Gatwick Airport Northern Runway Project – Development Consent Order (DCO)

Summary of Written Representations for Deadline 12th March

Gatwick Area Conservation Campaign (GACC)

12th March 2024

Diagram 3.3.1: Model performance before and after adjustment, Generic zone

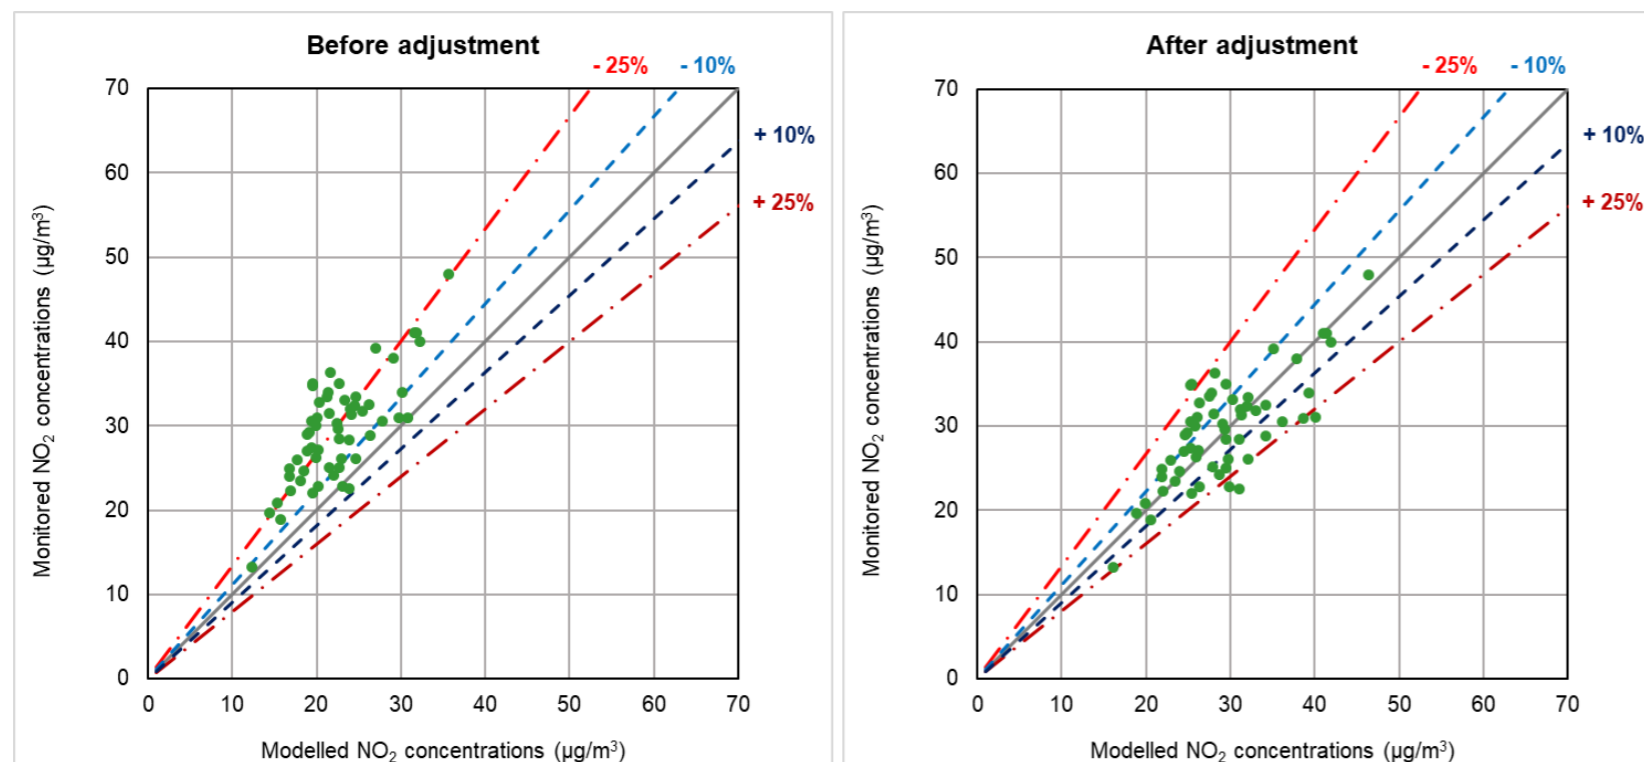
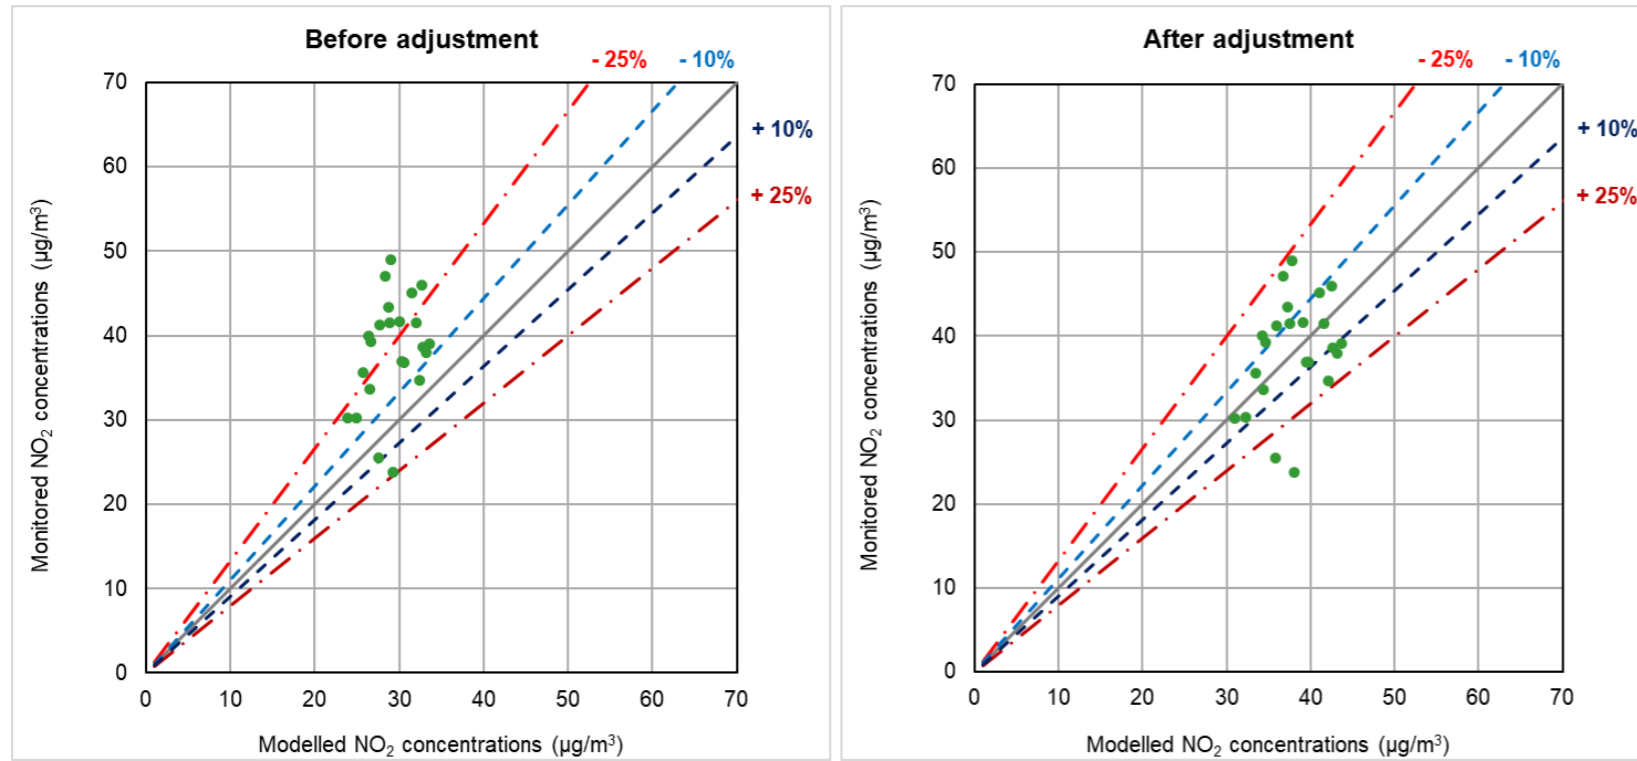
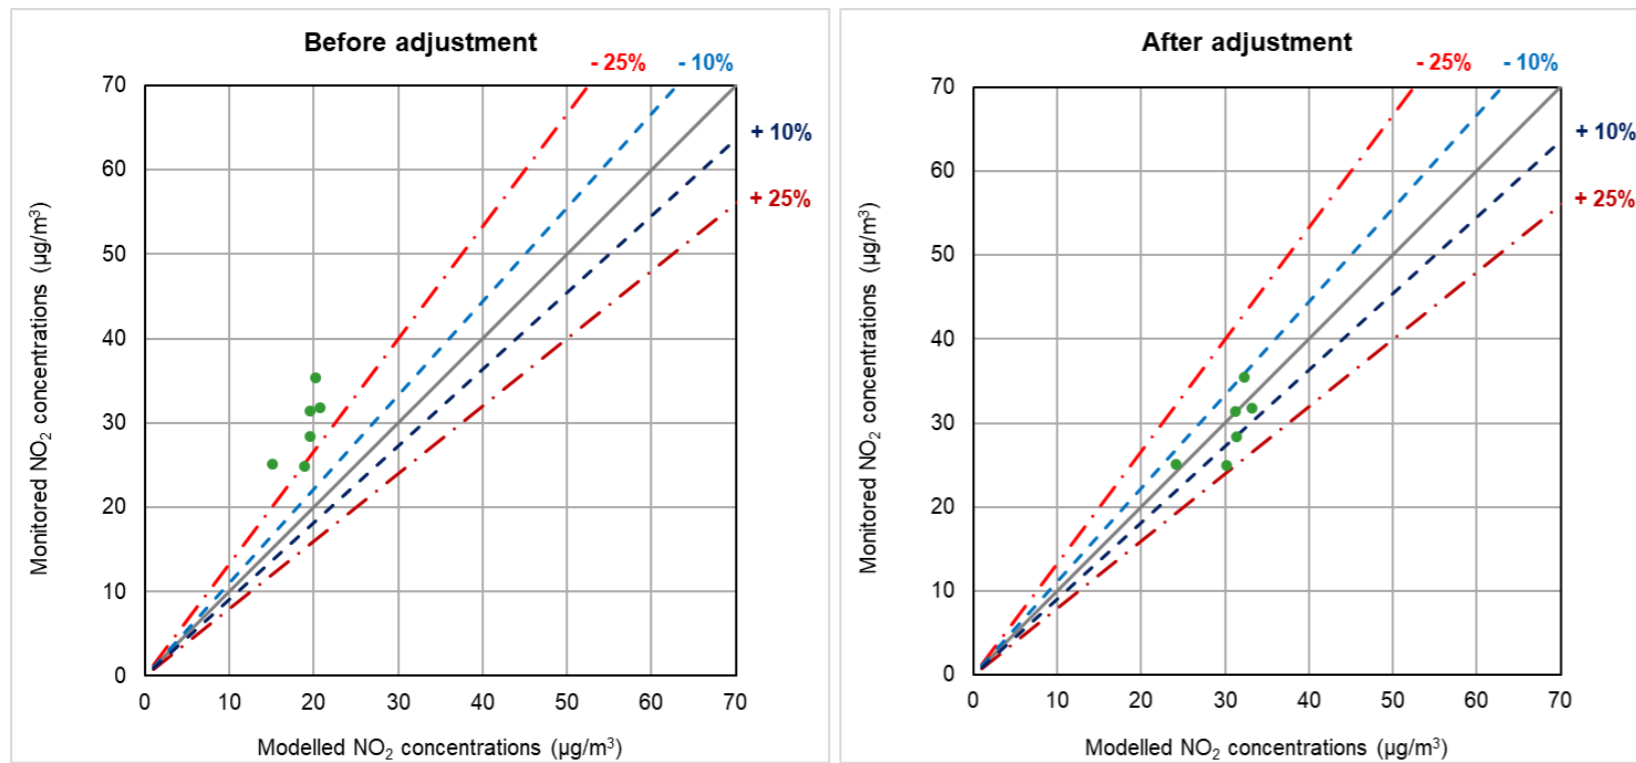
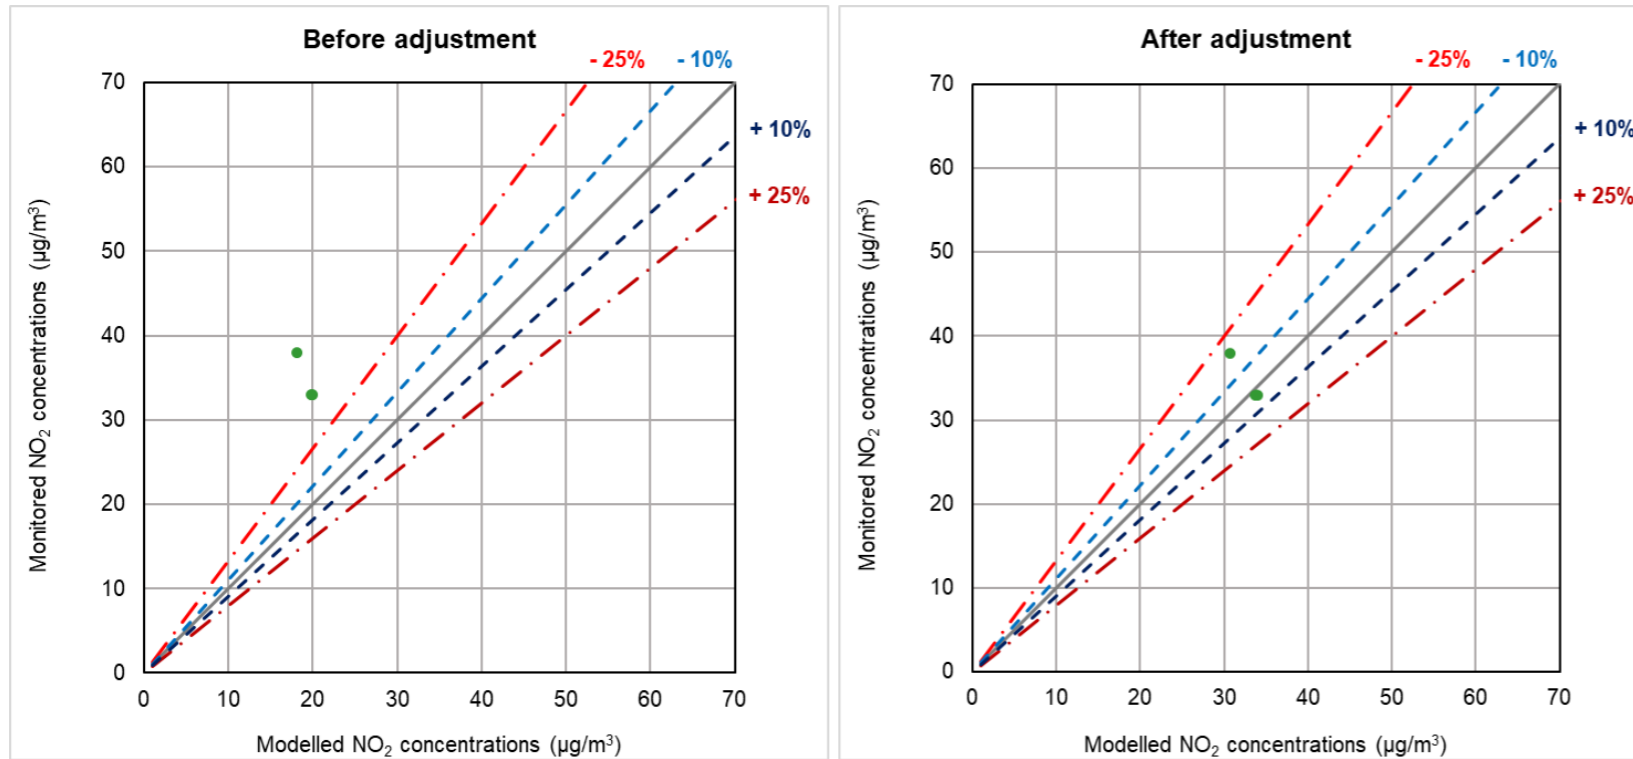
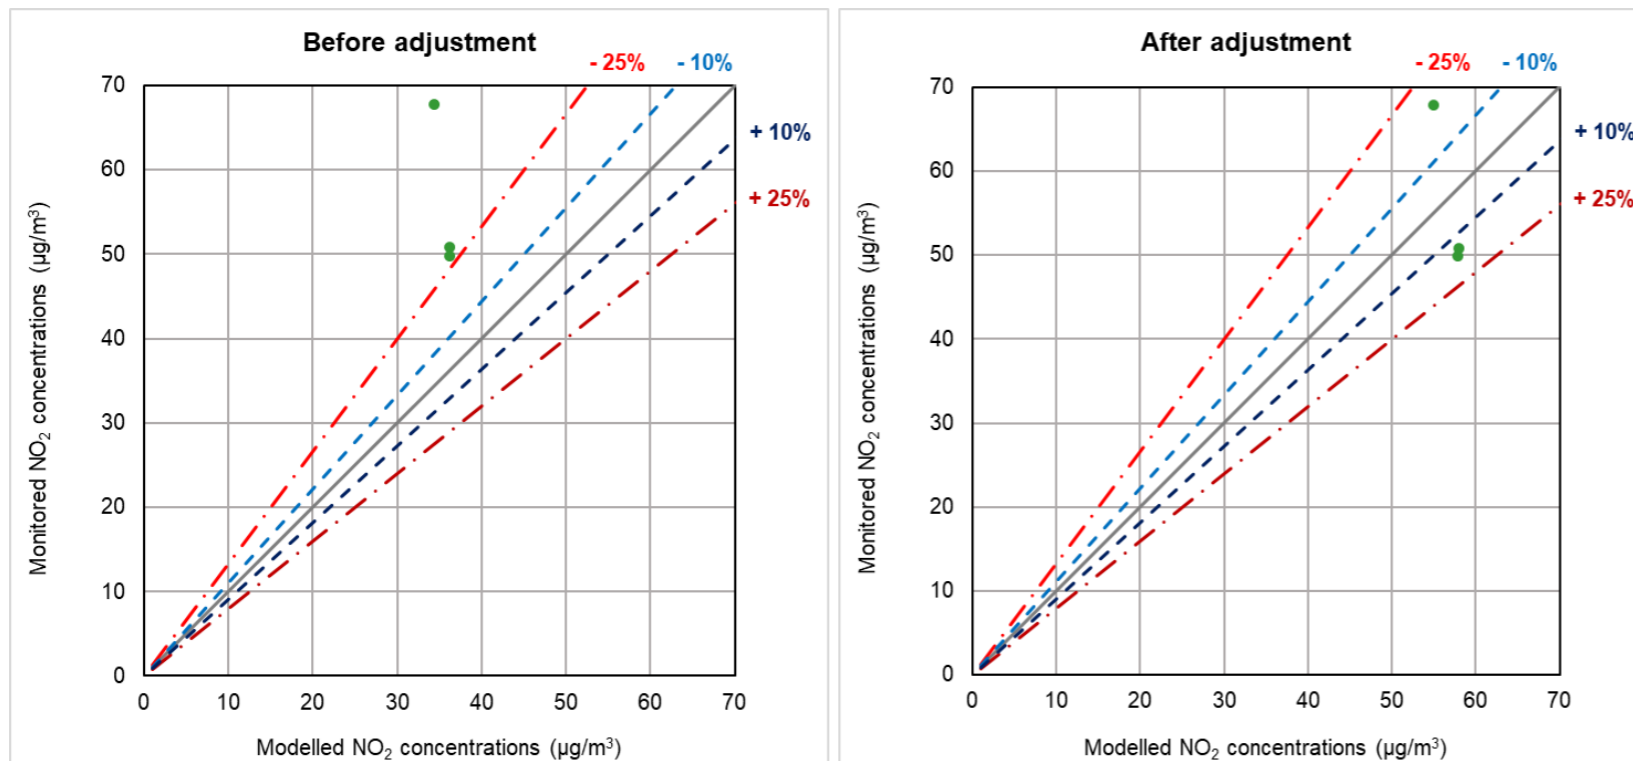
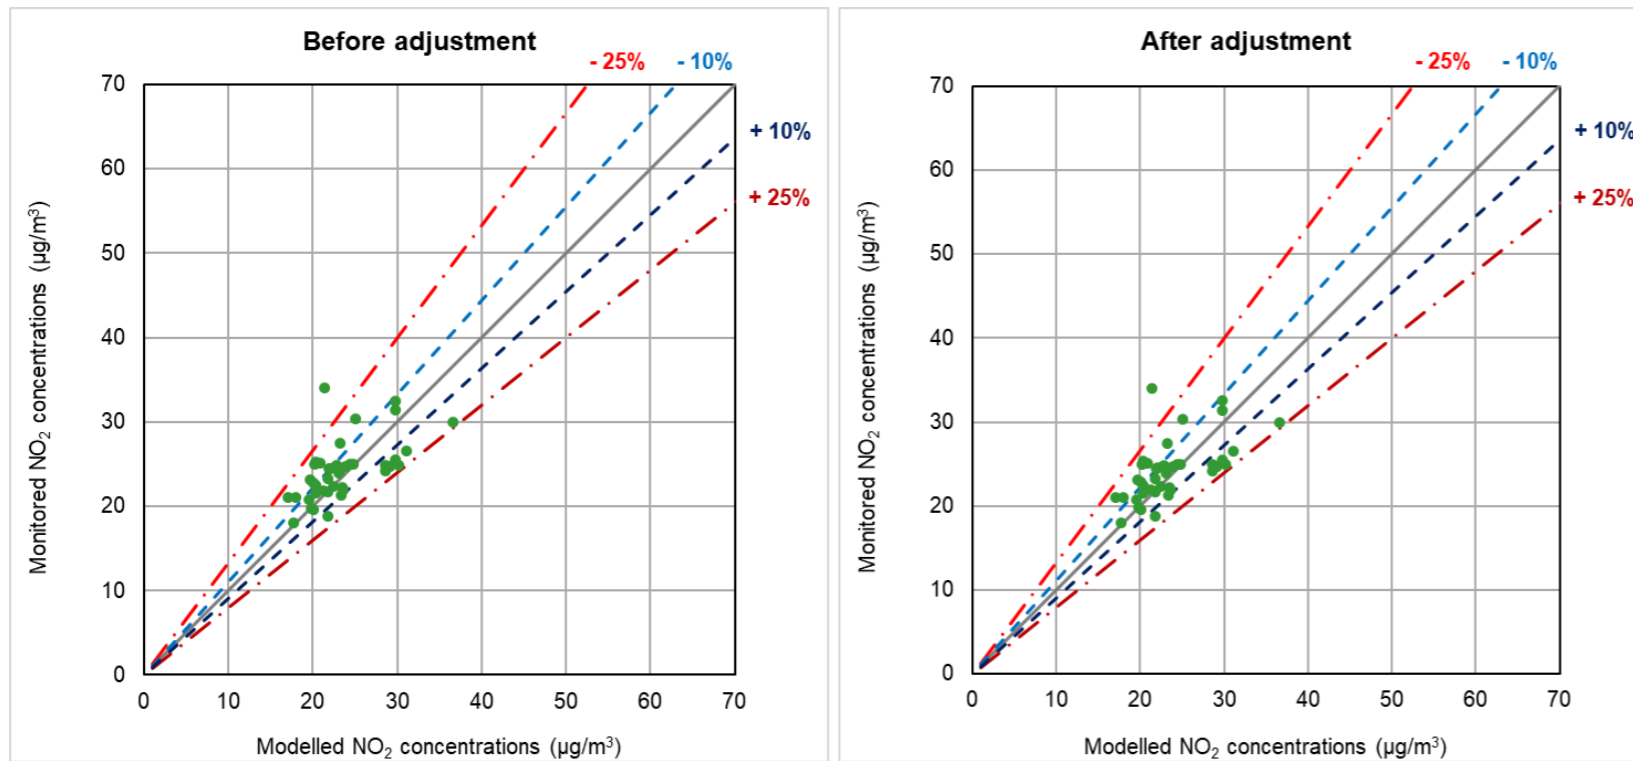
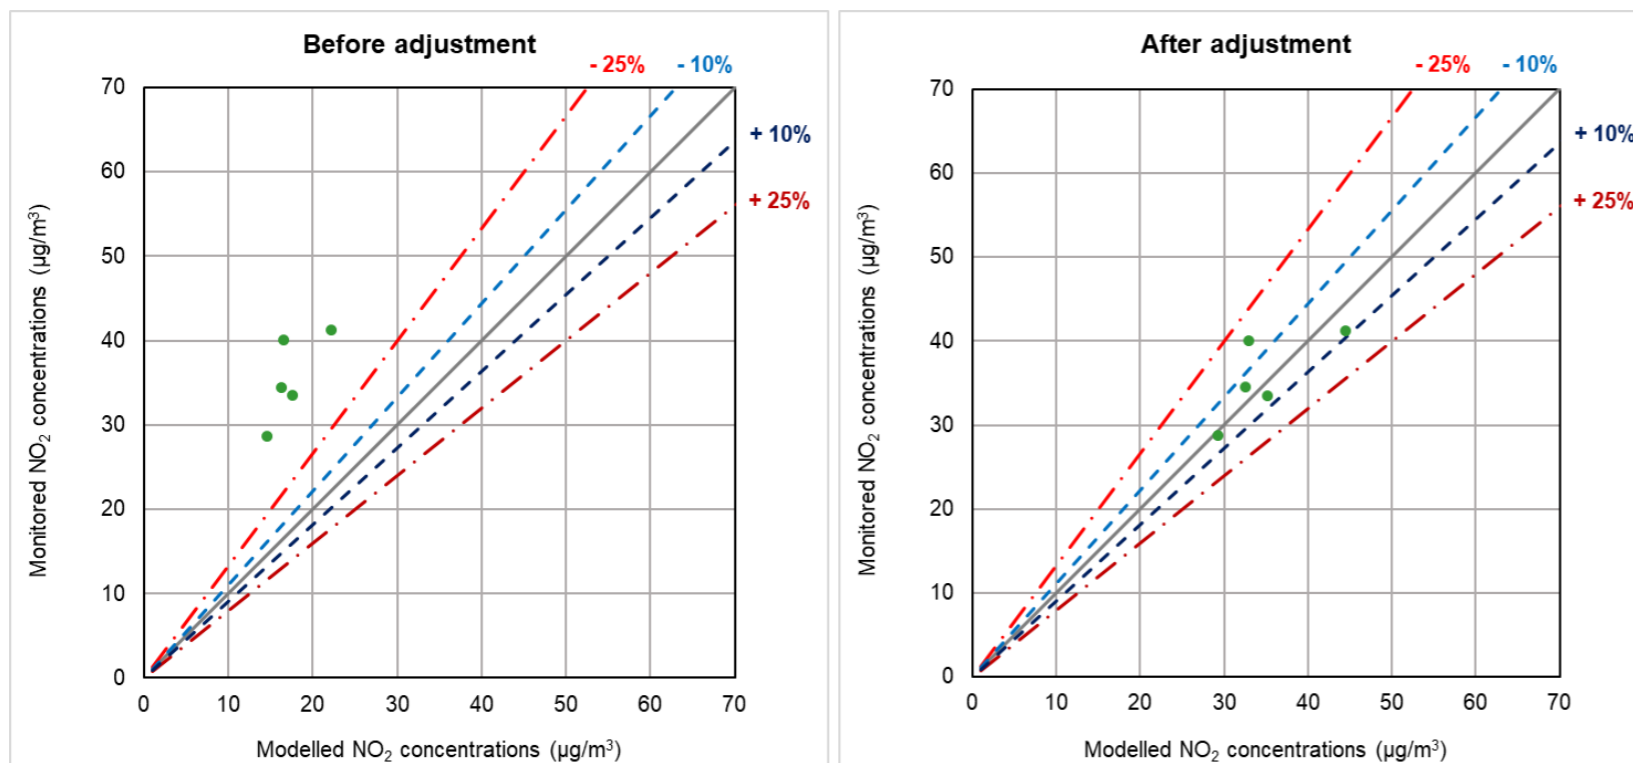
4. The confidence in the modelled air quality levels for future years is severely undermined by substantial inaccuracies in all of the aforementioned items. In particular the values for the baseline-modelled year (2018, especially for NO₂) are crudely adjusted to force a fit to the monitored air quality data. For this reason GACC propose that the model is made available for public scrutiny and that an independent statistical review is carried out to validate the assumptions and adjustments to better align the model data to the monitoring data and to review the quality of the monitoring data that is being used.

5. In our view, the modelling must not be relied upon to demonstrate that the future project impacts are not significant.
6. To make this data more robust, GAL should be required to annually review the accuracy of modelled data throughout the development stages, ensuring appropriate mitigation measures are in place should significant impacts be found. This should include reviews on the robustness of pollutant emissions inventories, with revisions of the air quality modelling to reassess and redefine the air quality impacts of the project at each stage to ensure no significant impacts are missed and not mitigated in a development of this scale. Furthermore, GAL should commit to substantially increasing the level of monitoring (covering the key pollutants of concern, particularly at sites vulnerable to project impacts e.g. schools, hospitals and homes likely to be impacted by an increase in road traffic or other airport-related emission levels) to ensure better quality baseline levels for future years upon which the project impacts are superimposed.
